Recommendation Report for Planning Permission for Works or Extension to a Dwelling

REF NO: R/242/21/HH

LOCATION: 9 Angmering Lane
East Preston
BN16 2TA

PROPOSAL: Erection of single storey rear extension and external alterations

A 02

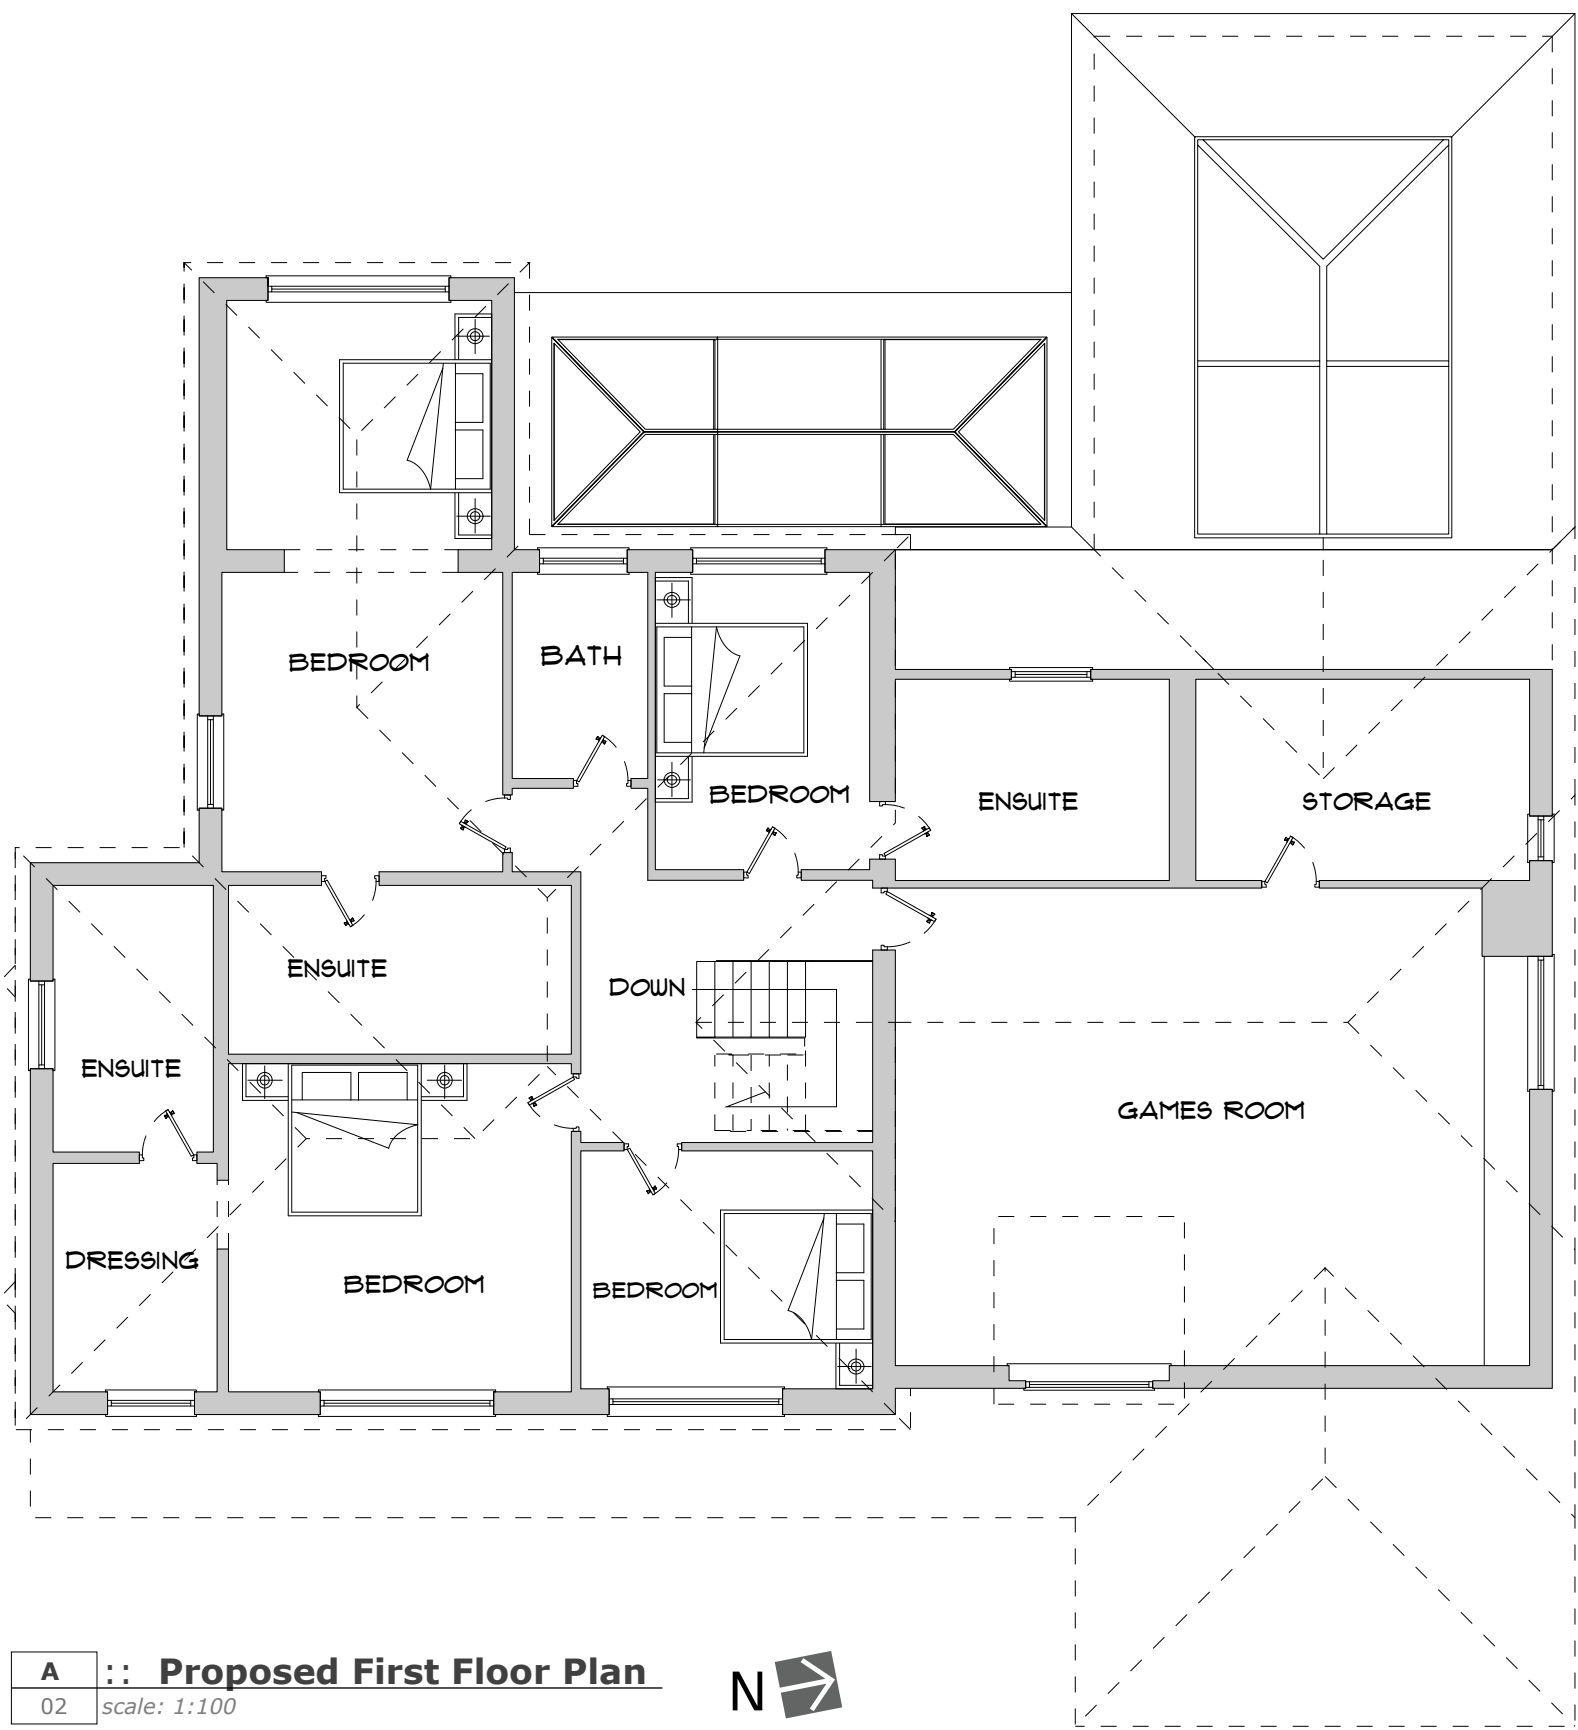
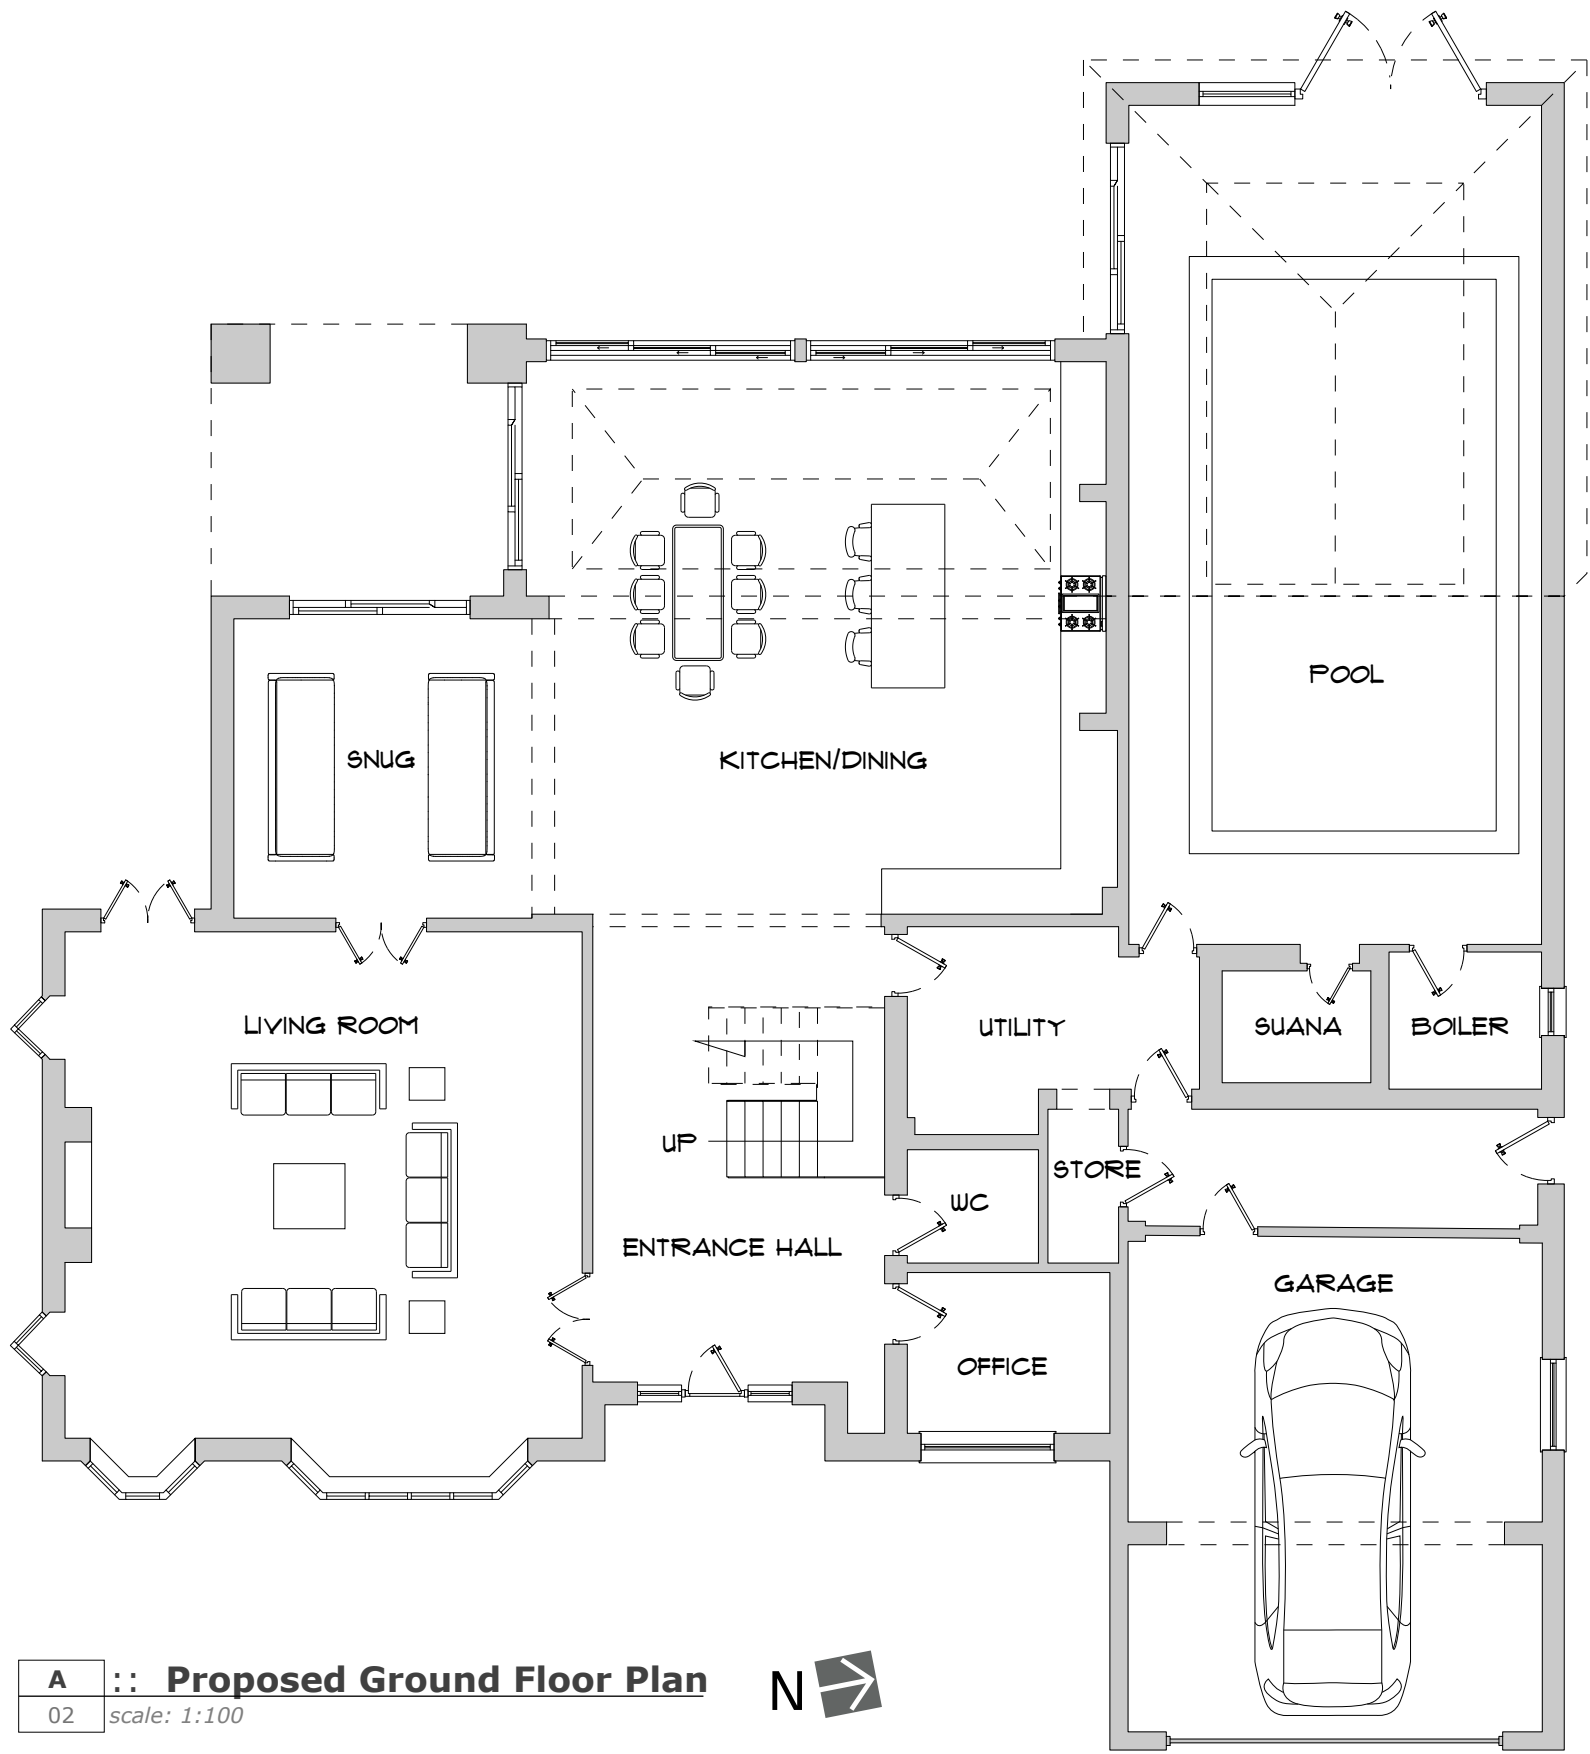
The proposed extension will have a flat roof design with a lantern light centrally located within the roof and being at single storey, is visually subservient to existing dwelling. The proposal will have a width of approximately 7.4mm and a depth of approximately 3.3m. The extension will not encroach on the side building lines created by the existing dwelling.

Design guidance states that rear extensions on detached houses, impacts on neighbouring amenity in terms of privacy and overshadowing can often be avoided by keeping single storey extensions within a 45-degree line taken from the edge of the nearest ground and first floor windows of habitable rooms in the neighbouring property. The extension will pass this 45 degree test so is acceptable.

The extension is centrally located within the plot and a good length of rear garden will be retained above design guidance recommended levels.

The proposed fenestration will face towards the rear private amenity space of the host dwelling as such it will only achieve views already obtainable from the host dwelling.
